Ref: SSD 9835

Re: SSD 9835 Sydney Football Stadium Redevelopment – MOD 2 – Response to Submissions

ATTACHMENT 1 SYDNEY FOOTBALL STADIUM FITNESS FACILITIES SSD 9835 MOD 2 – SUBMISSIONS SUMMARY & RESPONSES

DRAWING
PLANTING PLANS
Ground Level - Quad C

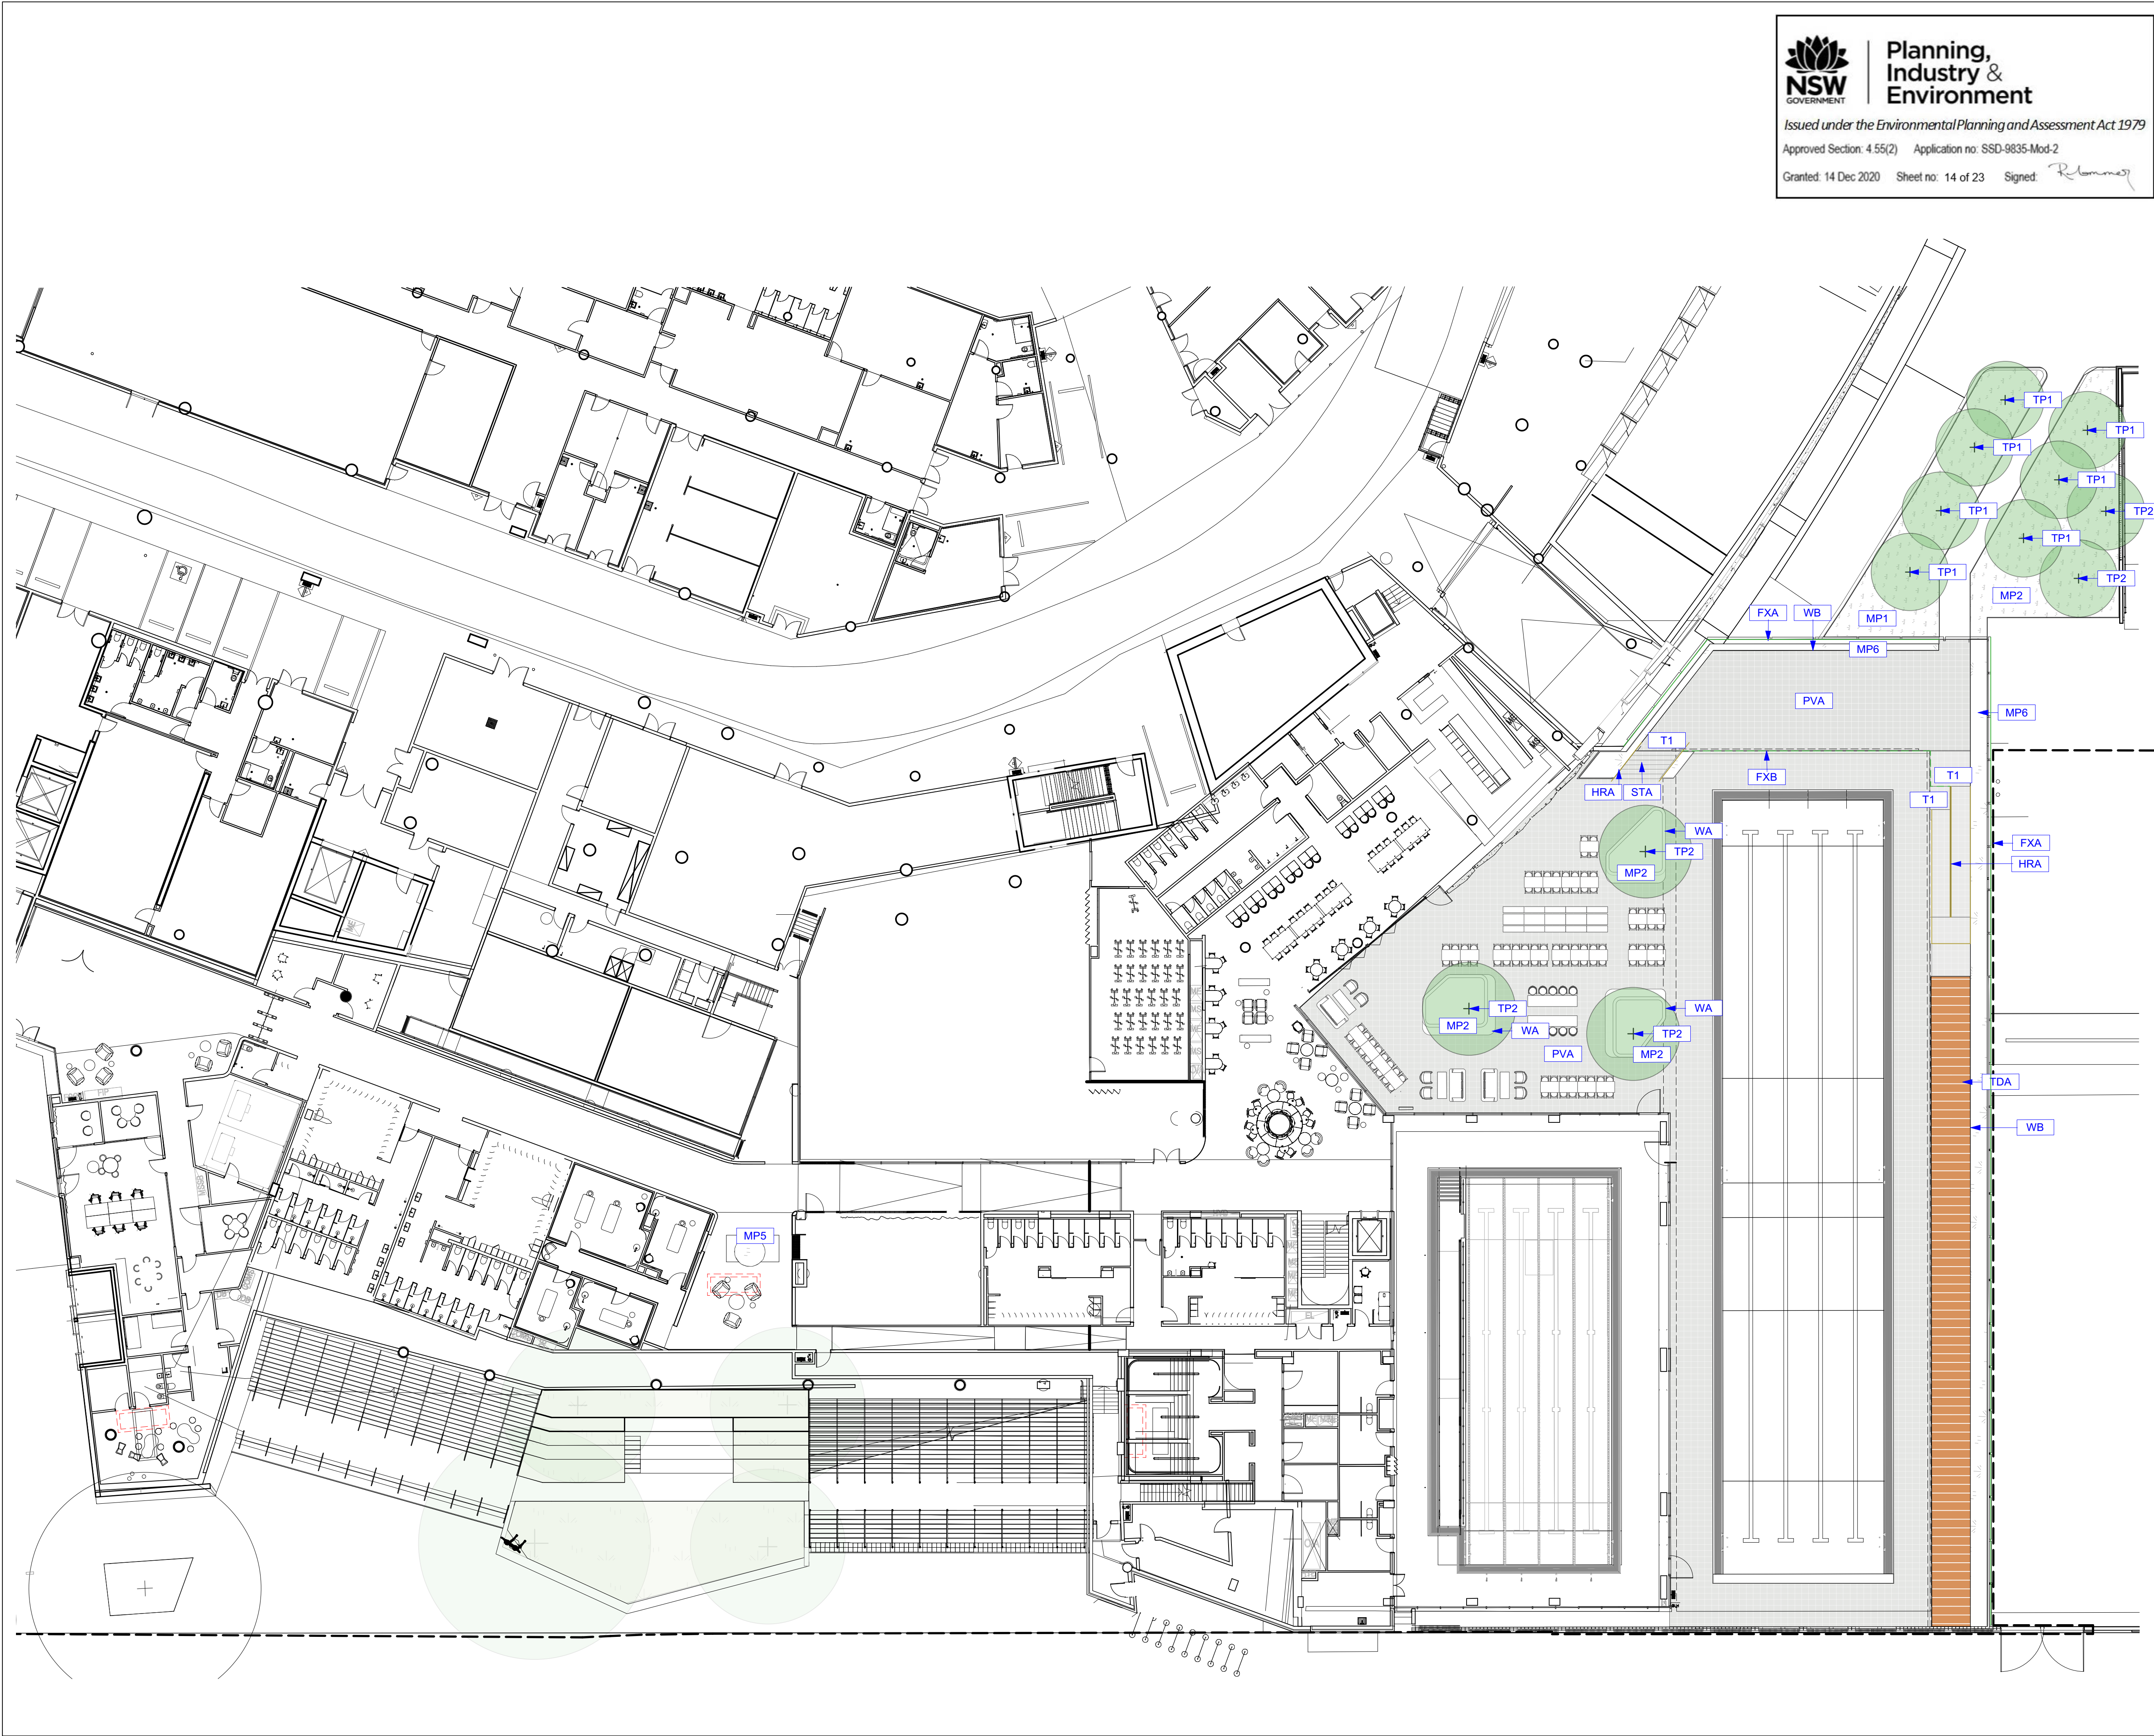
Landscape The landscape design report submitted with the RTS is general in nature and does not provide an indicative plant schedule. As such, there is insufficient information provided to assess the species selection for mass planting and plant mixes within the development to confirm whether a viable landscape design with improved biodiversity values is achieved for the development.	- The proposed plant schedule for the mass planting area mix A-M, in particular plant mixes A, B K, L, M are identified in drawings LA-001 or LA-003 which form part of landscape plans package that was submitted and exhibited as part of MOD 2. - Since the exhibition, the detailed package has been finalised and consequently the planting mix A, K, L, M and planting mix B are identified in the following drawings prepared by Aspect and provided at Attachment 4: - o SFS-ASP-00-DR-LS03XX01 Tree & Planting Schedule; - o SFS-ASP-02-DR-LS02XX00 Legend & Schedules.

The submitted design report proposes extensive roof gardens on the Level 2 and 3 roof terraces using a native plant mix. However, these are misleading in that the plans and images provided are for perimeter planters with succulent species that are native to Mexico and South America. Whilst on trend and appropriate for a resort or hotel, the use of succulents in the landscape design is not considered sympathetic to the parklands and increasing biodiversity and habitat creation of the Moore Park and Centennial Park precinct.	- The proposed roof terraces planting selection is identified in SFS-ASP-02-DR-LS02XX00 Legend & Schedules and indicates 70% of the proposed species selection is native species. - The selection of Banksia and Grevillea specifically speaks to the Moore Park and Centennial Park precinct plants character.
The landscape design and plant schedule are to be amended to employ hardy native species with a preference for drought resistant species that contribute to habitat creation and biodiversity. Overall, the landscape package is to provide	- The detailed package has been finalised and consequently the planting mix A, K, L, M and planting mix B are identified in the following drawings prepared by Aspect and provided at Attachment 4: - o SFS-ASP-00-DR-LS03XX01 Tree & Planting Schedule; - o SFS-ASP-02-DR-LS02XX00 Legend & Schedules.

Issue	Infrastructure NSW Response
further detail to public domain material schedules and plant schedules as well as details for all planters, planting on slab, green roofs and internal planting.	- The planting selections include native species such as Banksia and Dianella which contribute to the local habitat creation and biodiversity for the Moore Park and Centennial Park precinct.
Noise – Demolition and Construction Noise The updated Noise and Vibration Assessment Report, prepared by Arup, indicate additional works associated with the construction of the Stadium Fitness Facilities would marginally increase the predicted noise levels by 1dB at some receivers. Increases of 1dB are considered imperceptible to the average person and these noise levels have already been approved via previous consents.	- Noted
The occurrence of the predicted noise levels would also be infrequent due to the low likelihood of the additional concrete pump truck and mobile crane operating concurrently with all other modelled construction equipment.	- Noted
